Planning Application Ref: BR/235/20/T

Location: 7 Countland Court, 5 Marine Parade, Bognor Regis, PO21 2LT

Description of works: 2No. sycamore trees reduce by 2m on circumference to leave 1m and to crown clean. 6No. sycamore trees to reduce by 2m on southside to leave 1m

REF 1

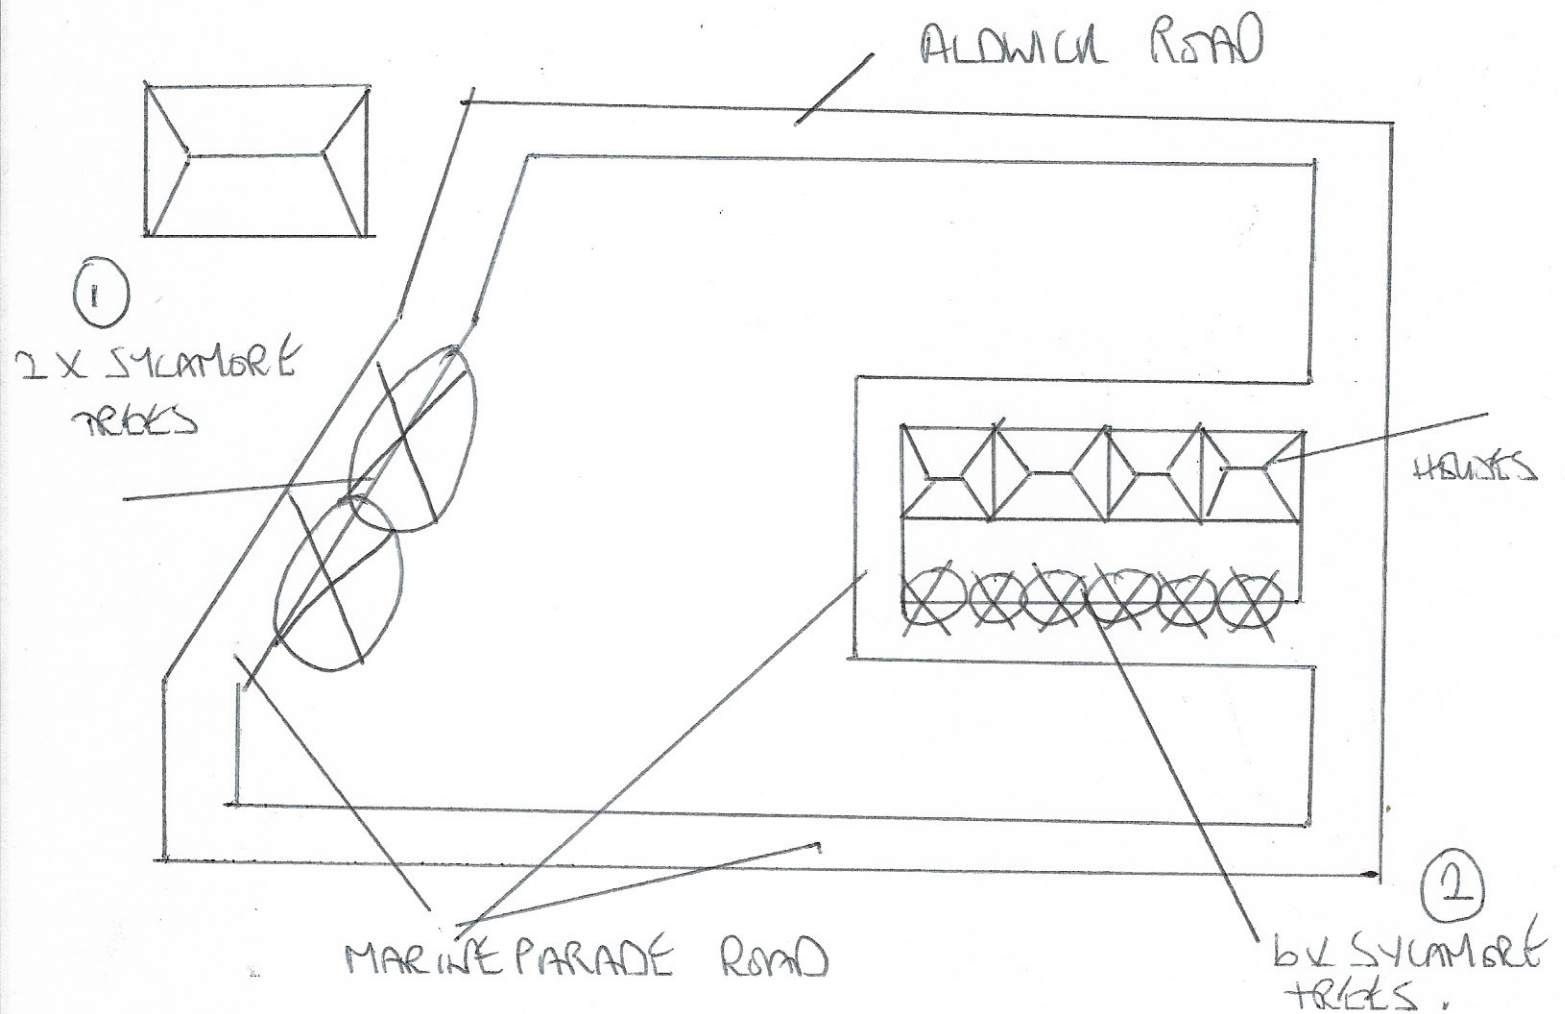
- Sketch plan showing position of two sycamore on east side of Marine Parade Road, where none exist. There are two obvious individual sycamore to the west of Marine Parade Road in the same vicinity, it is assumed those are the subjects. It should be noted at this point that the northern tree grows from within the curtilage of 37 Aldwick Road (my reference T12). The southern tree appears to grow from within Marine Parade Road (private) and assumed to be under group management (my reference T11).

- T1-T10 is a linear group of similarly managed (crude pollards) trees, running east-west in the rear gardens of Anton Cottages. There appear to be 6 individual lime and 4 sycamore, so it is not clear which trees are the subject of the application.

- The work specification (reduction of circumference) is not recognised within British Standard (BS3998:2010) Tree work – Recommendations and is not possible to satisfactorily interpret from site. A *crown reduction* proposal must accurately describe the height and spread (metres) remaining on all aspects, post-pruning.

- I am unable to concur with the reasons stated as being sufficient to justify the proposed work.
- The trees are a significant feature in the local landscape and appear to be in adequately sound and healthy condition. The tree surgery proposed in the application would result in excessive reduction of their landscape impact and undue detriment to the visual amenities of the locality.

T11 - I recommend **REFUSAL**.

T12 - I **recommend the making of a Tree Preservation Order** to preserve this tree's place in the landscape and better control future management.
